Comment on SEARS - Proposed Dangerous Goods Facility

– Warehouse 3b Oakdale Central , Horsley Park, within Lot 21 DP 1173181

Comments are based on the publication by Willow Tree Planning ‘ Request for Secretary’s Environmental Assessment Requirements Proposed Dangerous Goods facility Warehouse 3B, Oakdale Central, Horsley Park 2 February 2016’

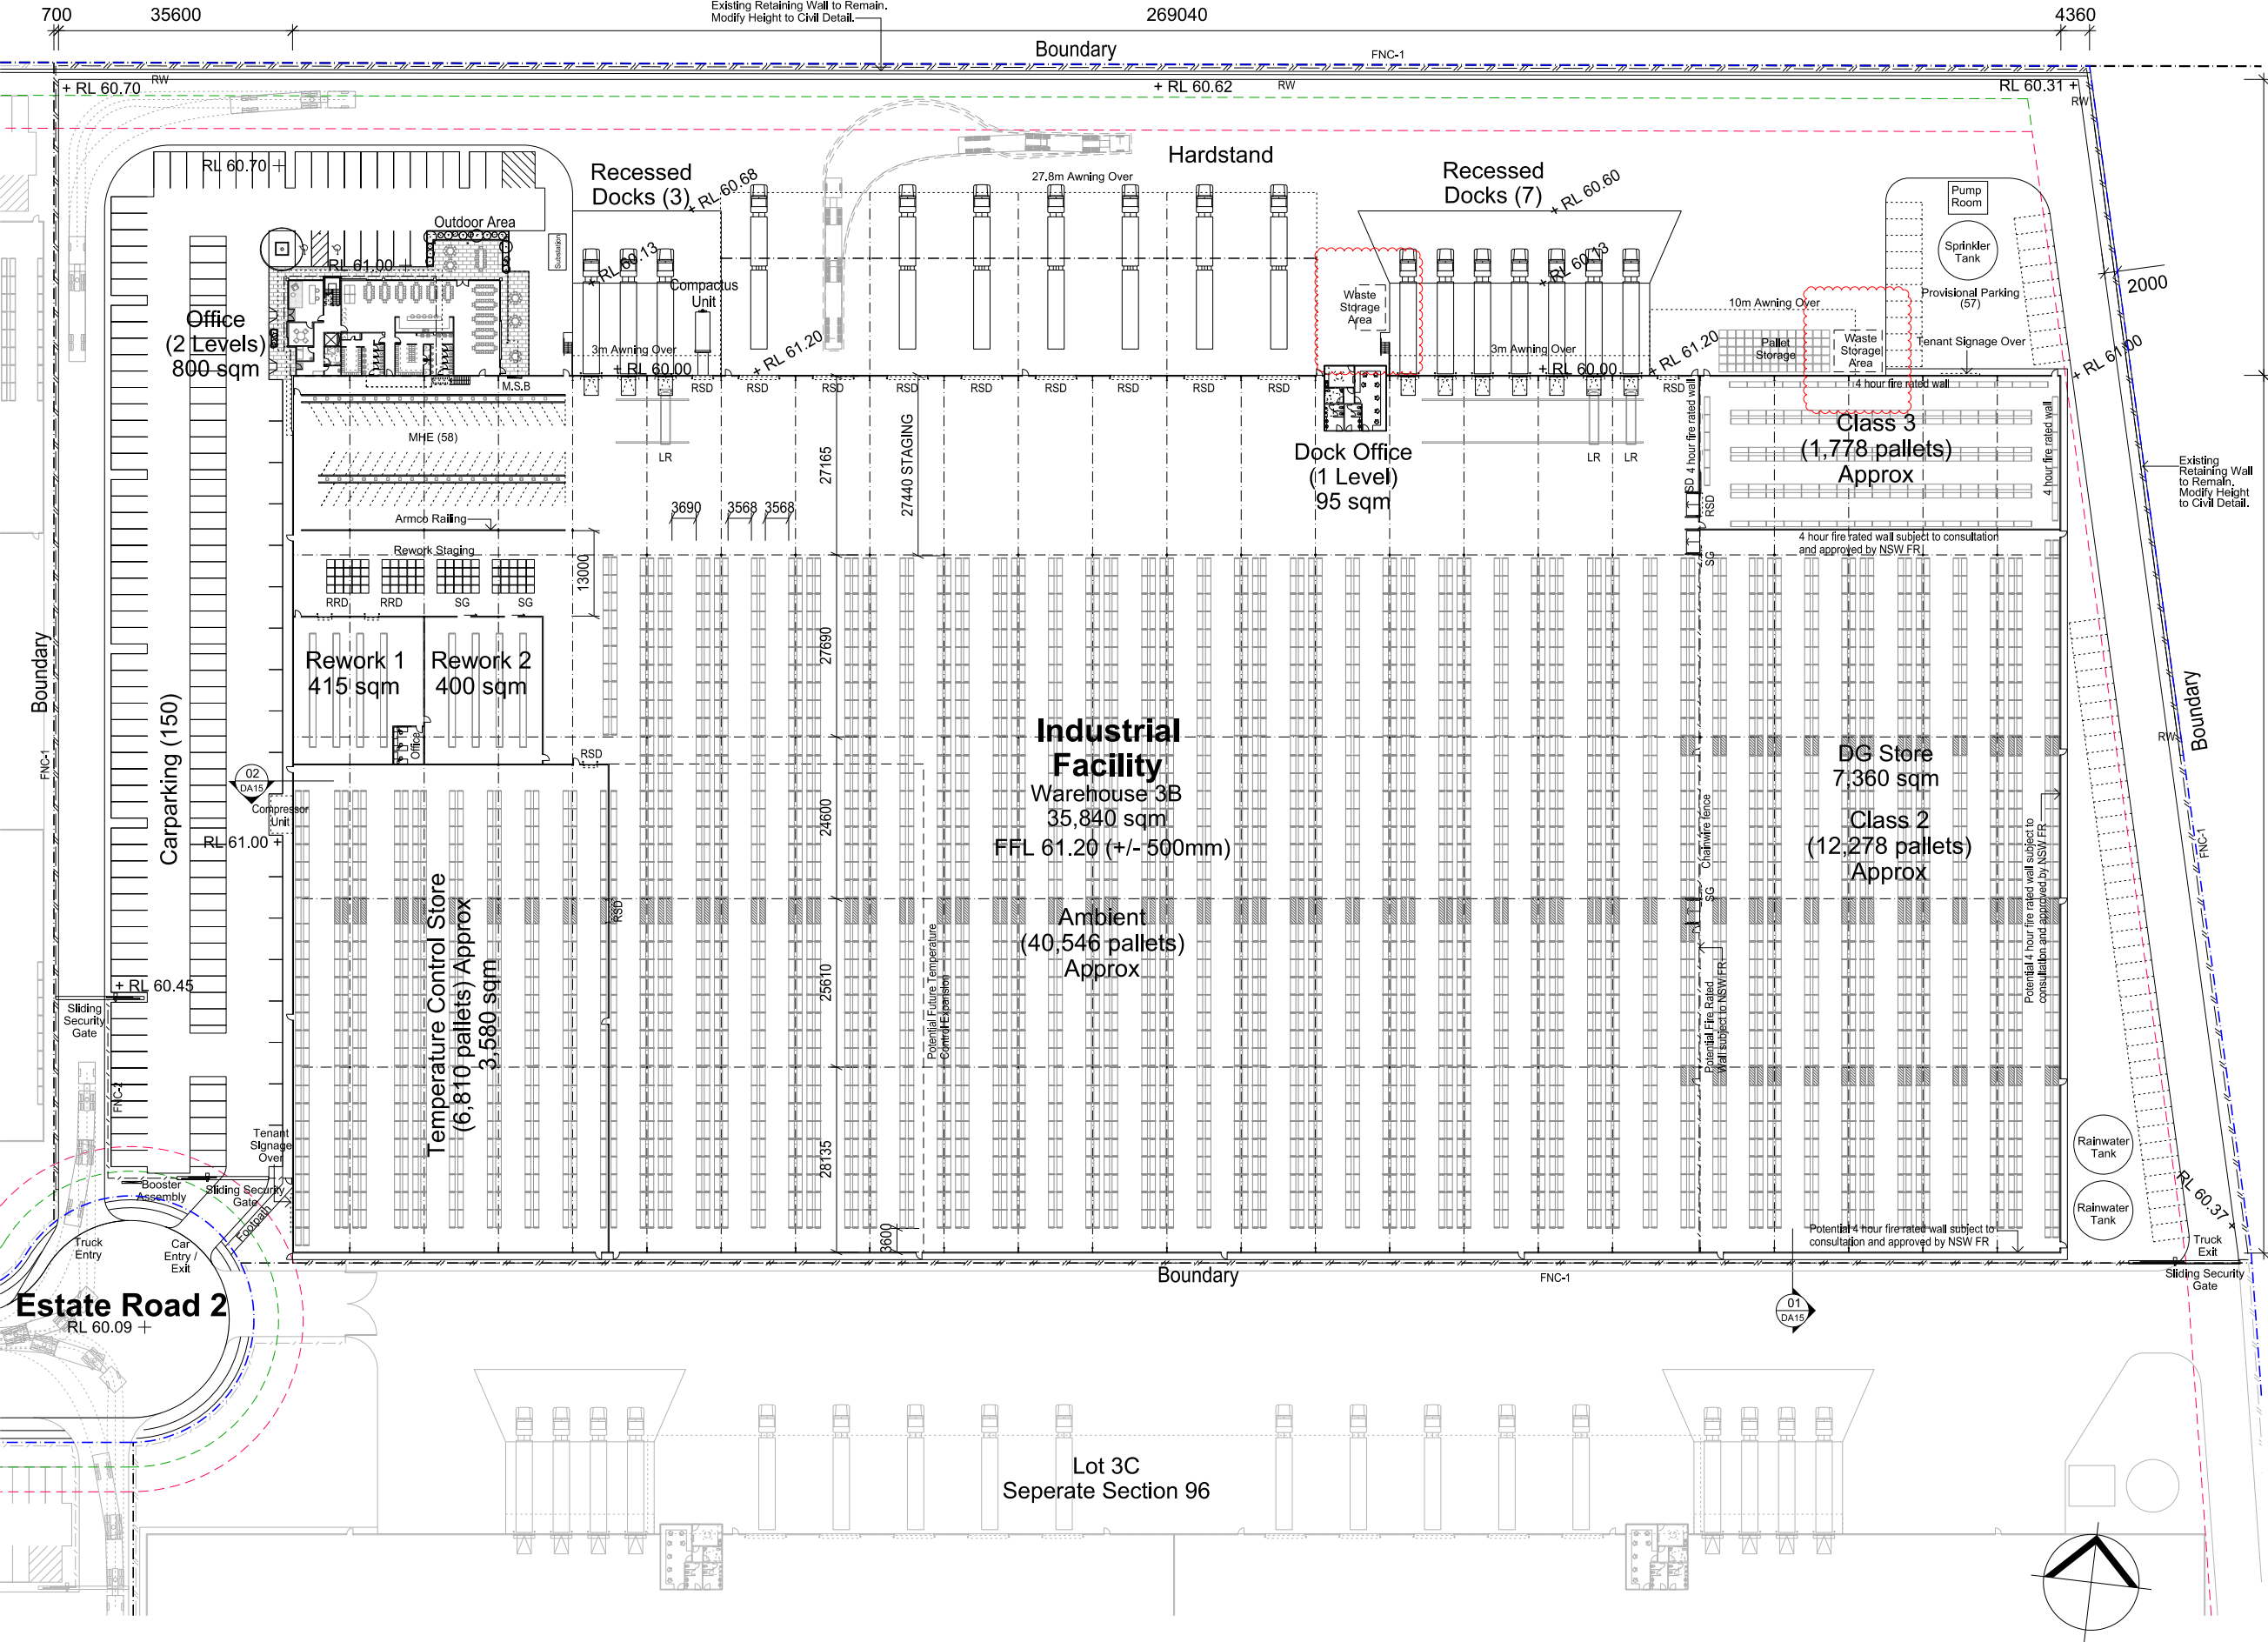
The proposed warehouse 3B will be sited within proposed Lot 3 which will be near the western end of existing Lot 21 DP 1173181. It seems that fill is being placed to raise Lot 3 above the 100year flood event. – Refer Figures 1 & 2.

The part F Environmental Assessment Table 4, Soil & Water indicates that all stormwater runoff from Lot 3 will drain to the east to Biodiversity Area B, which will be used for on-site detention purposes. Lot 3 without modification would in part drain to the north and west to Ropes Creek.

Hence it is important that contaminants from the Dangerous Goods Facility are able to be contained before entering Ropes Creek (to the west of Lot 3) or the Ropes Ck. tributary (to the east of lot 3).

Given it is proposed to store Class 2(Aerosols), Class 3 (Flammable) and Class 8 (corrosive substances) within the facility, it is important that risks of explosion, spillage, and leakage are controlled so that contaminants are not able to reach Ropes Creek.
